From: Robert Findlay
Sent: 28 July 2014 15:20
To: Planning.Responses
Subject: FW: Planning Consultation on: LU/182/14/PD

APPLICATION NO: LU/182/14/PD

Site Address: 1 & 2 Norfolk House Wick Street Littlehampton

Description of Works: Prior notification under Class 1A for change of use from A1/A2 (retail/financial & professional services) to C3 (dwellinghouses)

DWG. NO / 010512 / TP.01.'A'

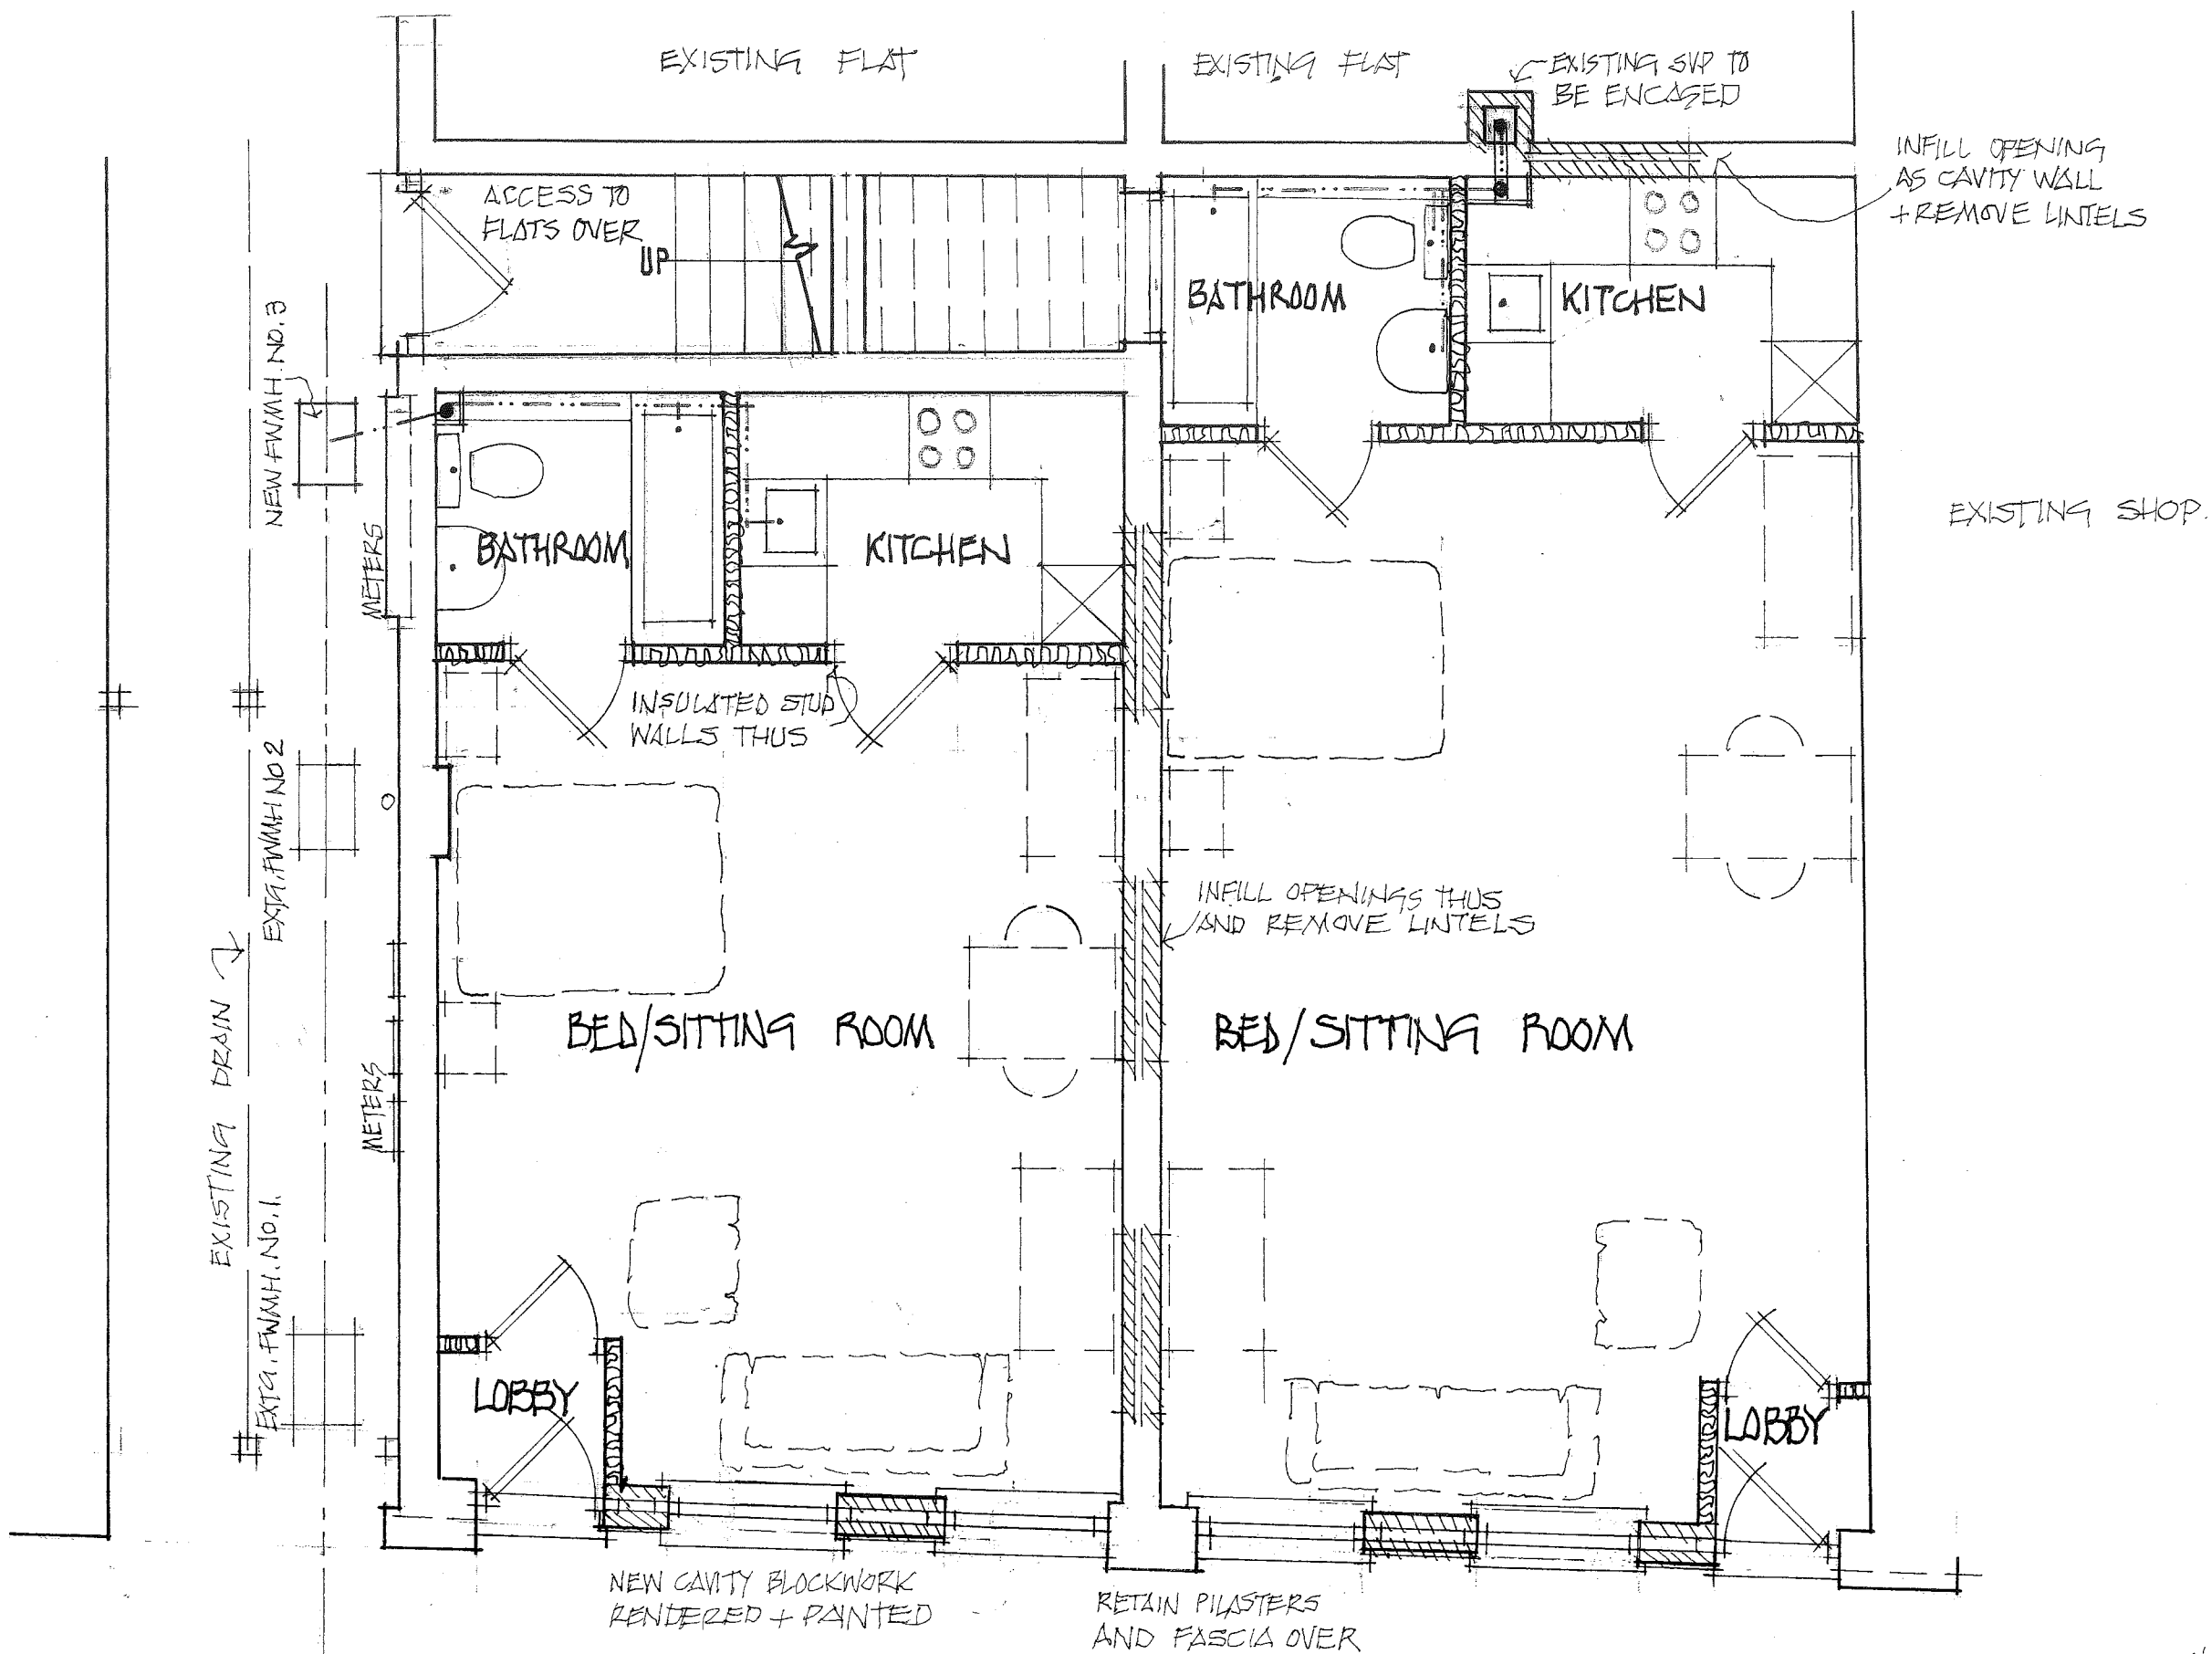
The kitchens are to be a minimum of 5.5sqm for 1 person or 6.5sqm for 2 persons
